**DELEGATED DECISION FOR APPLICATION FOR CERTIFICATE OF  
LAWFUL DEVELOPMENT**

Reference no.: 2023/CL/92300/W

Site: Whinney Close Farm, 106, Cockley Hill Lane,  
Kirkheaton, Huddersfield, HD5 0PF

Description: Certificate of lawfulness for proposed single storey  
side extensions

APPLICATION DRAWINGS

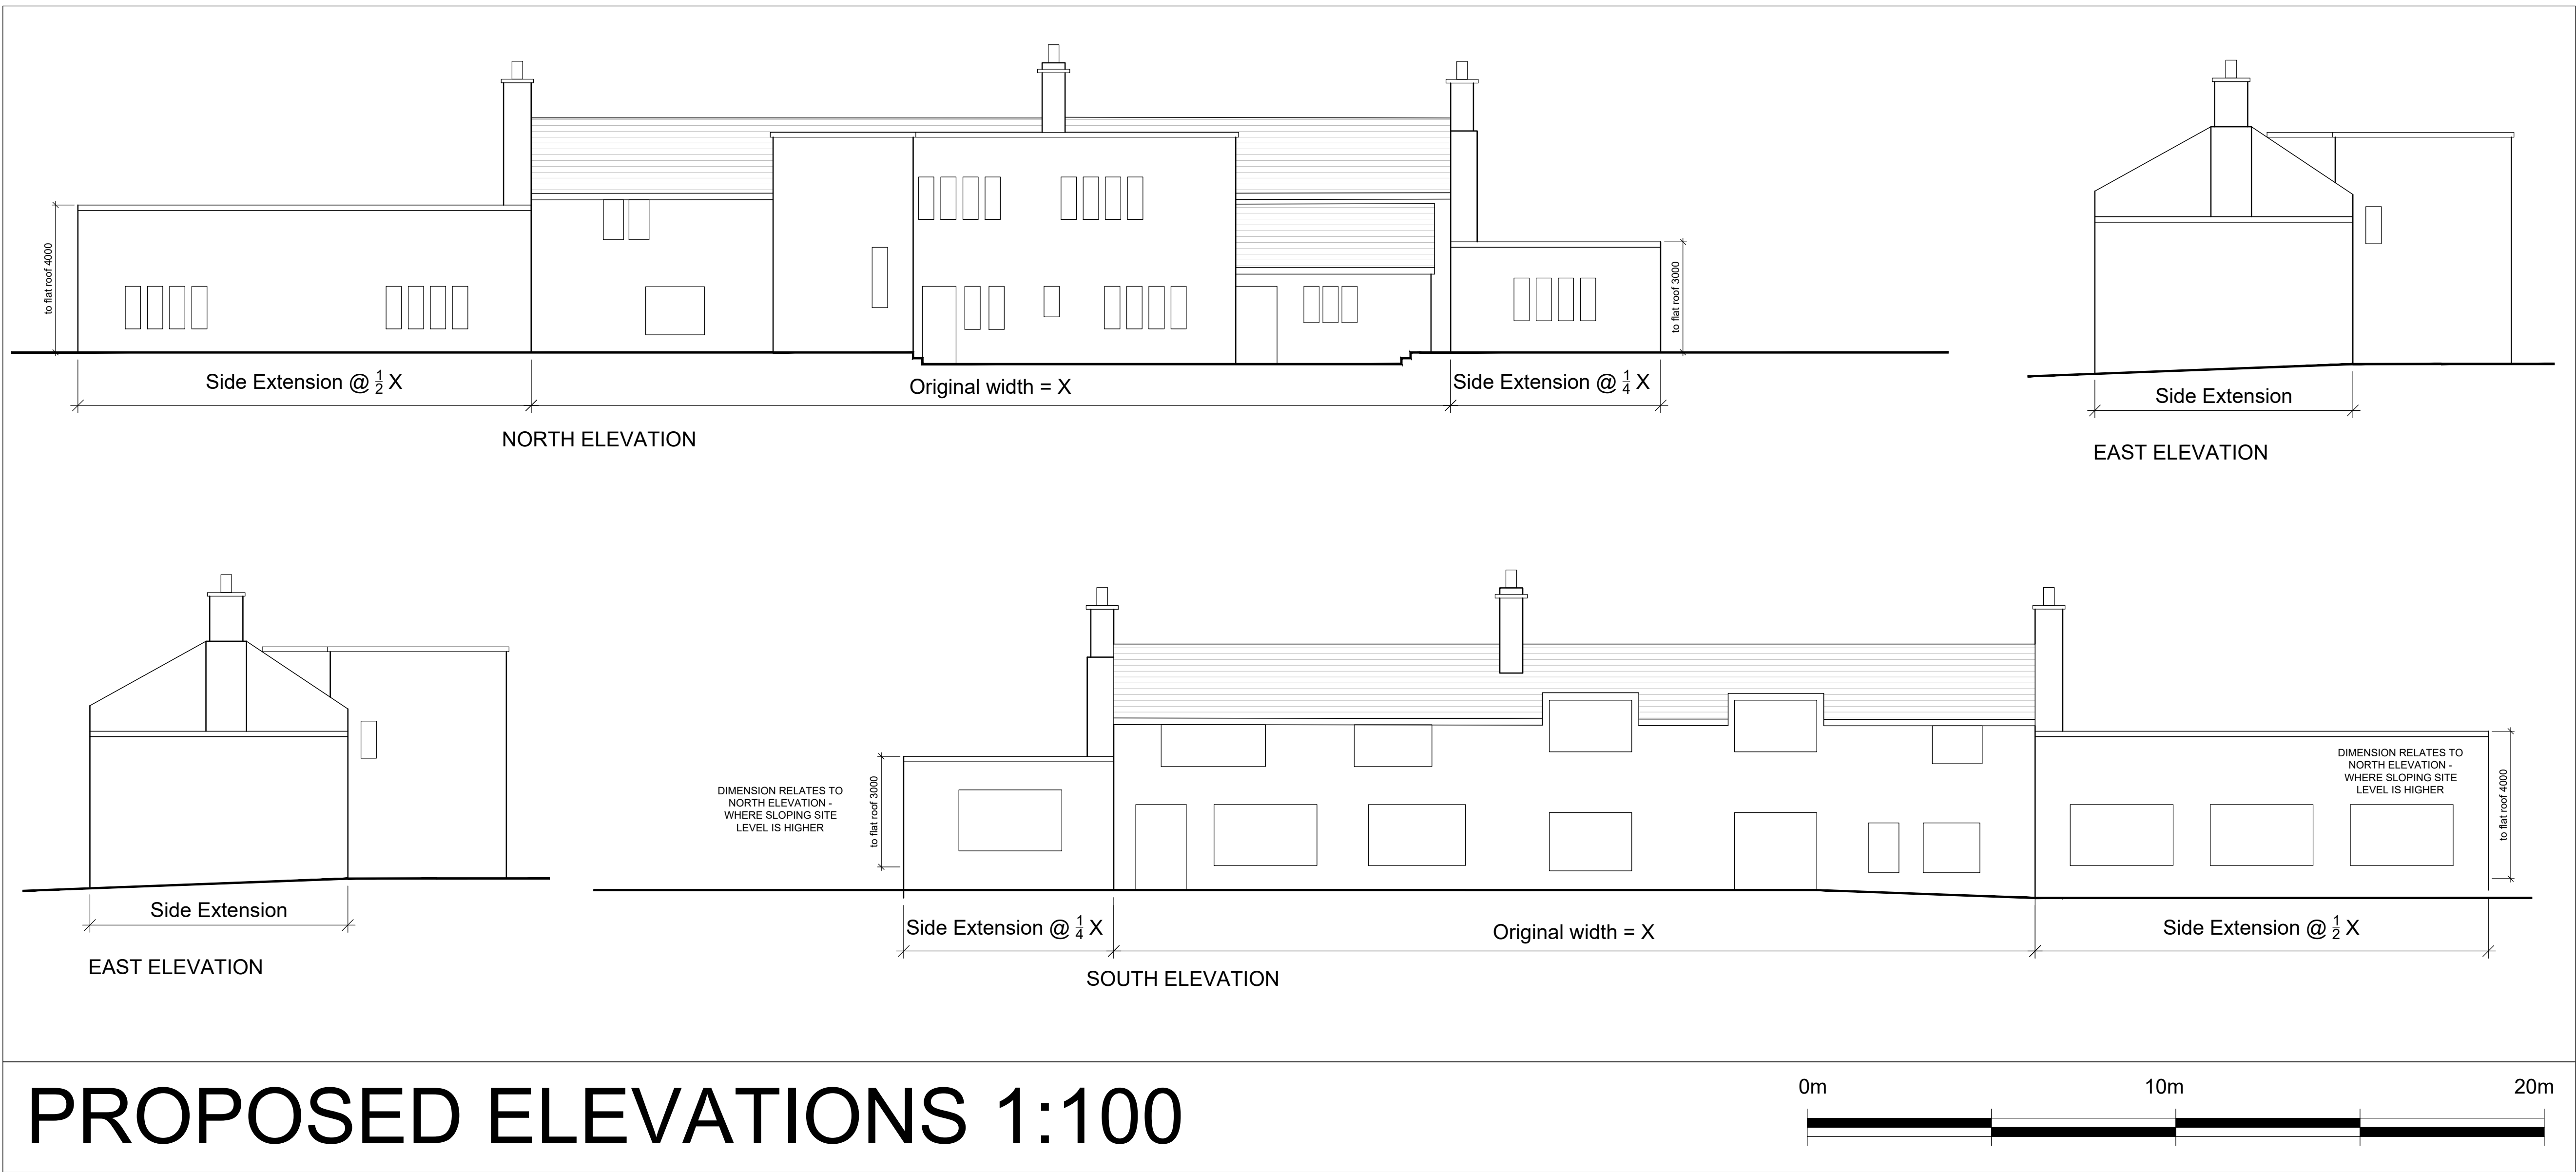
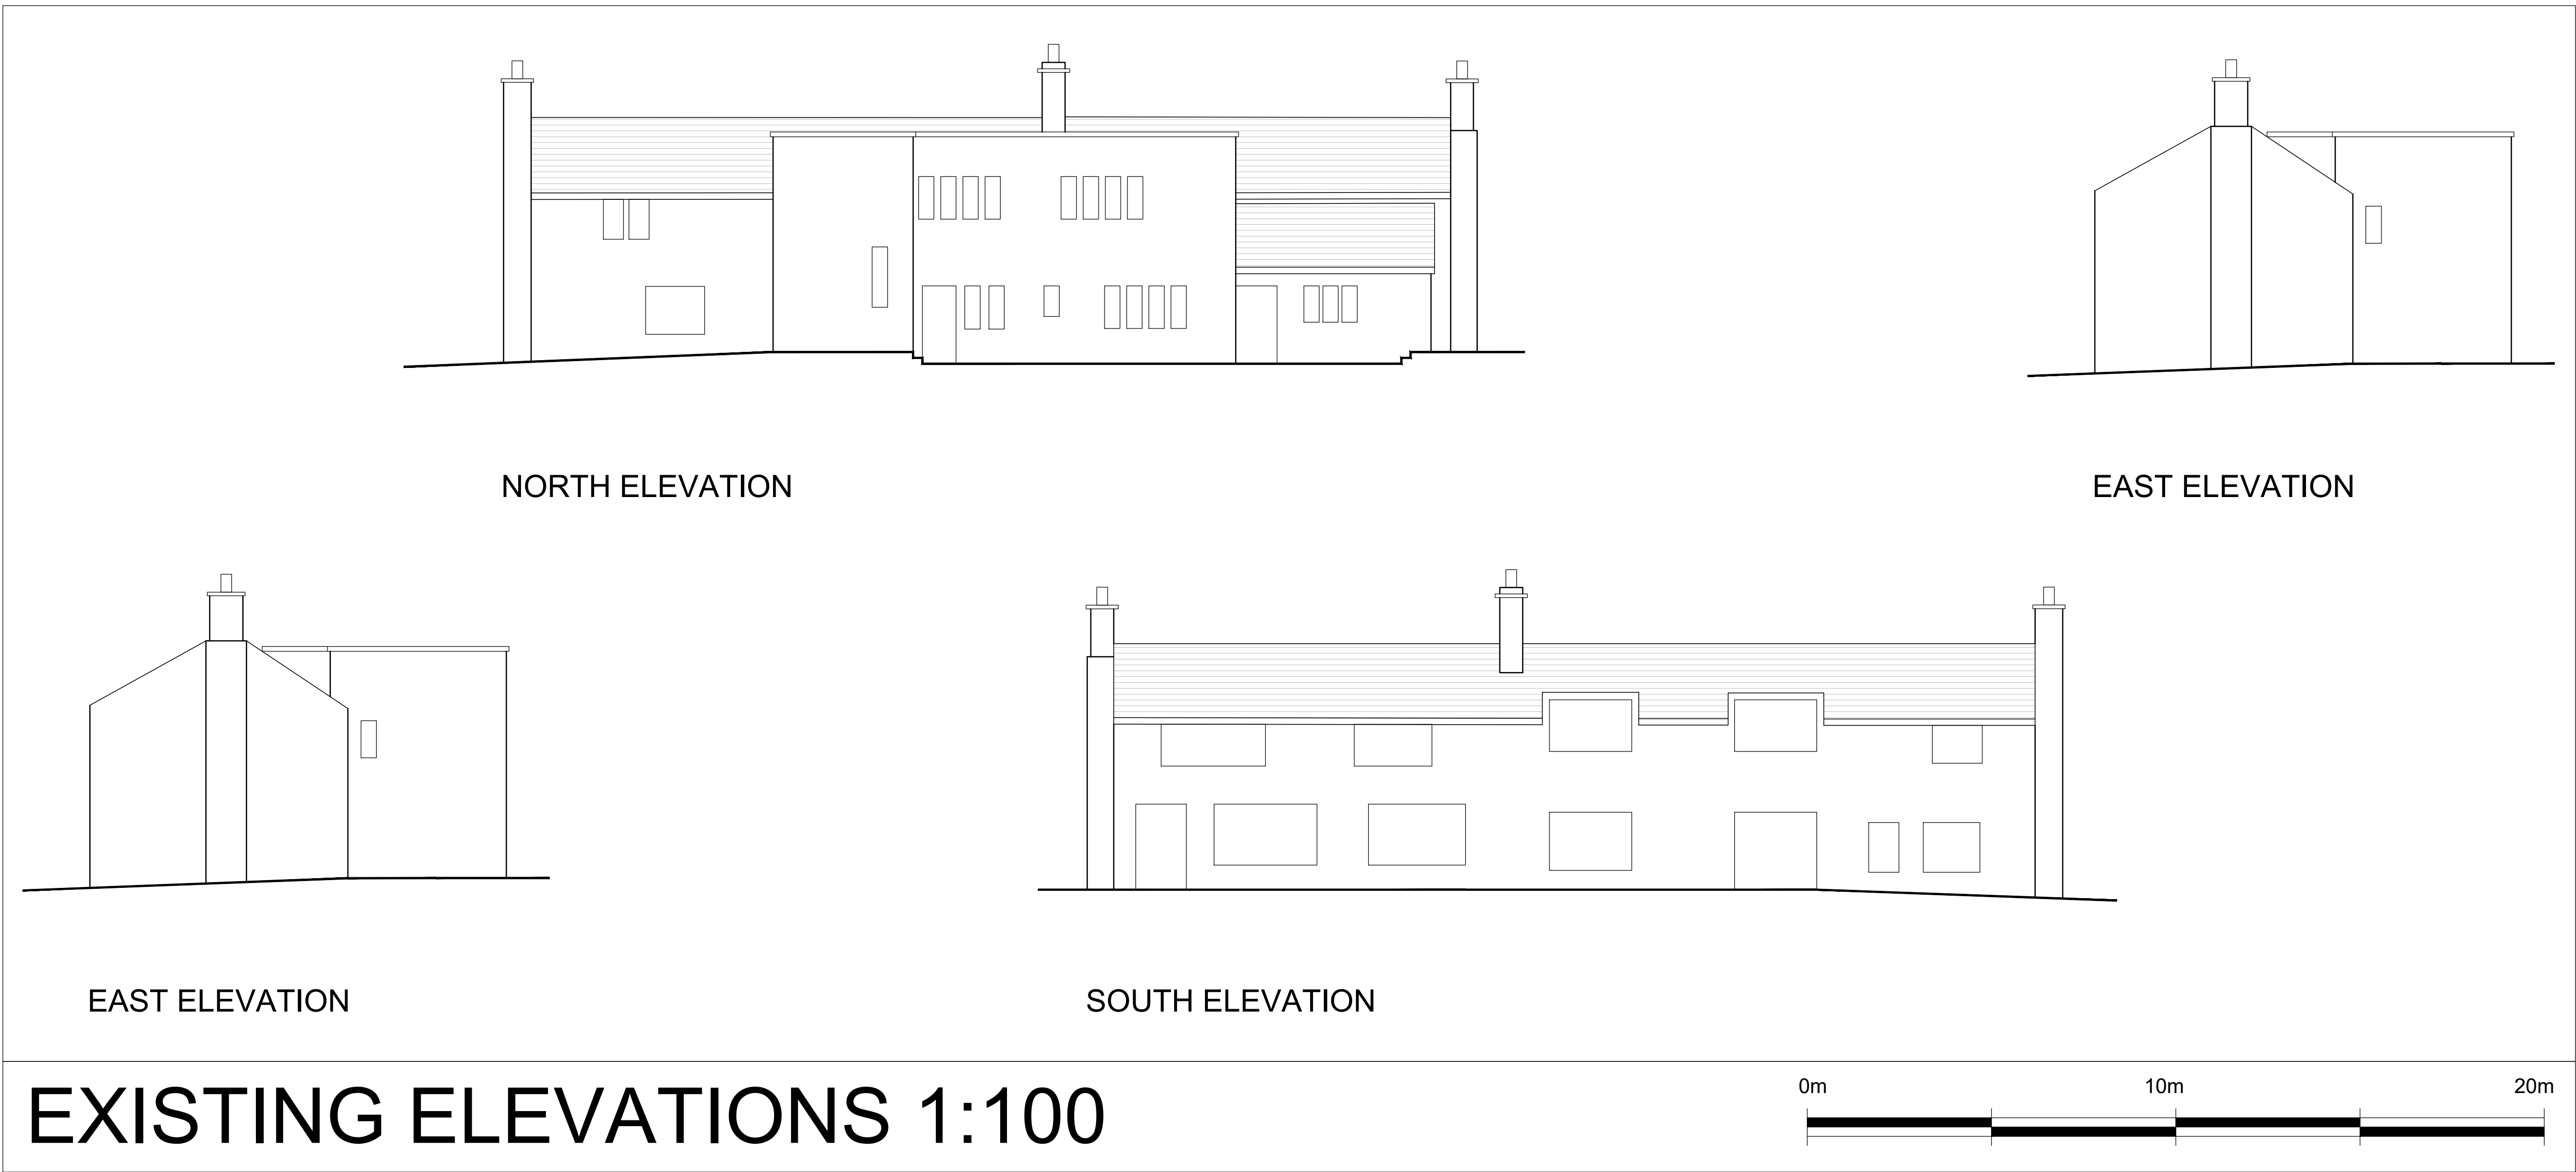
- 5.3 An amended plan was submitted (498/02-02-100 B, replacing 498/02-02-100), 18<sup>th</sup> September, reducing the scale and height of the western extension after the architect was notified of the case officer's concerns that, as originally proposed, it would not fit into the recognised curtilage.

6.8 The plans have been amended during the application process and now show an extension extending to the west by 5.7m. This would extend to within approximately 0.5-1.0m of where the historic curtilage boundary is presumed to be, and would not extend into the recently-acquired area referred to in the paragraph above. There is therefore no longer any reasonable doubt that both elements of the proposal fall within the recognised curtilage boundary.

**Comment:** The enlarged (western) part of the dwellinghouse would be within 2m of the original boundary of the curtilage of the dwellinghouse and eaves height, measured from the highest part of the adjacent ground level, would not exceed 3m.

**Comment:** The proposed extensions, as previously noted, would not exceed 4m in height and would be single-storey. The applicant's drawings show the existing dwelling to be 24.9m in length. Measurements based on Kirklees aerial photographs indicate a length of between 24.5 and 24.0m. The case officer's own measurements taken on site verify the length as being 27m which would mean that the eastern extension, at 12.3m, would be within the limit of 50%. There is no obvious explanation for the discrepancy between the case officer's site observations and those derived from aerial photographs and plans. Even if the lowest figure (24.0m) were taken to be definitive, however, the extension would only marginally exceed half the width (by 300mm) and the case officer concludes that on the balance of probabilities all of the limitations in A.1(j) are complied with.
